Re: Status of Improvement Permit Application #06-5-14870 - Lot 126 Woodshire

On June 1, 2006, an Environmental Health Specialist from the Harnett County Health Department attempted to evaluate your property for the purpose of issuing an Improvement Permit. This individual was unable to evaluate your property for one or more of the following reasons.

SURVEY FOR:
PROPOSED PLOT PLAN - LOT - 126
WOODSHIRE S/D, PHASE FOUR

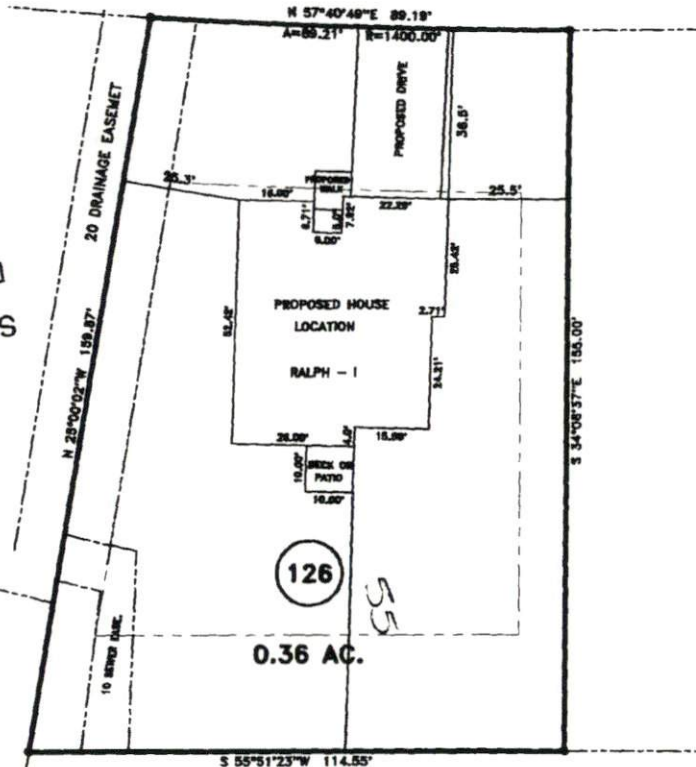
6. Other – **Due to the amount of fill on lot, please have your consultant provide a septic system and repair layout and meet me on site. Call me between 8 - 9:00 a.m. to schedule.**
